From: David Pickford <[REDACTED]>
Sent: 19 September 2019 14:16
To: Anita Gardner <[REDACTED]>
Subject: FW: 22 Beach Road, Littlehampton.

As per below, we are just seeking clarification that you would have no issues in planning terms with the required window acoustic vents to habitable rooms for the noise mitigation for this site.

Subject: 22 Beach Road, Littlehampton.
Importance: High

Figure 7. Review of 1-hour periods inside Flat 1 bedroom

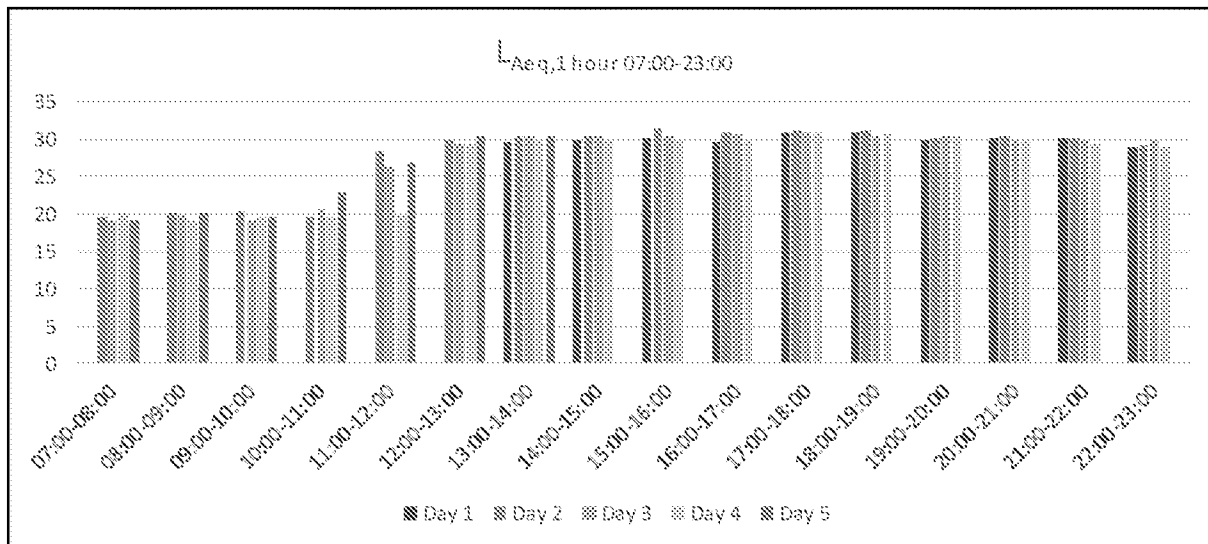
In respect of your report, 23rd August, page 3, paragraph 3 then to clarify, my comment related to **Figs 6 & 7** and **Flat 1** where daytime noise was found to be 28.8 with windows closed and therefore 39 to 44dB with reasonable adjustment for an open window.

Figures 6 and 7 in the report relate to Flat 1, however the references to 39 and 44dB relate to Flat 2, front bedroom, which is reported in Figure 10.

Figure 4. Location of Condensers serving Walk in Chiller

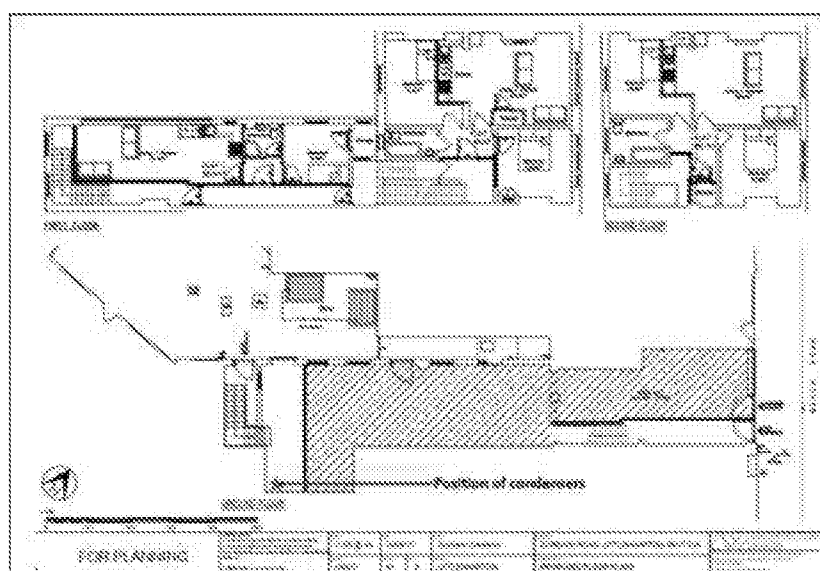
1. The condenser unit for the Walk in chiller.

The condensers were previously located below the bedroom window but have since been relocated to inside the rear garage unit at the very rear of Flat 1, outside the demise of the flat.

The condensers are mounted on anti-vibration mounts on the ground floor. Both the garage and the pizza hut ceiling were soundproofed at the same time. The condenser positions inside the garage void are shown below.
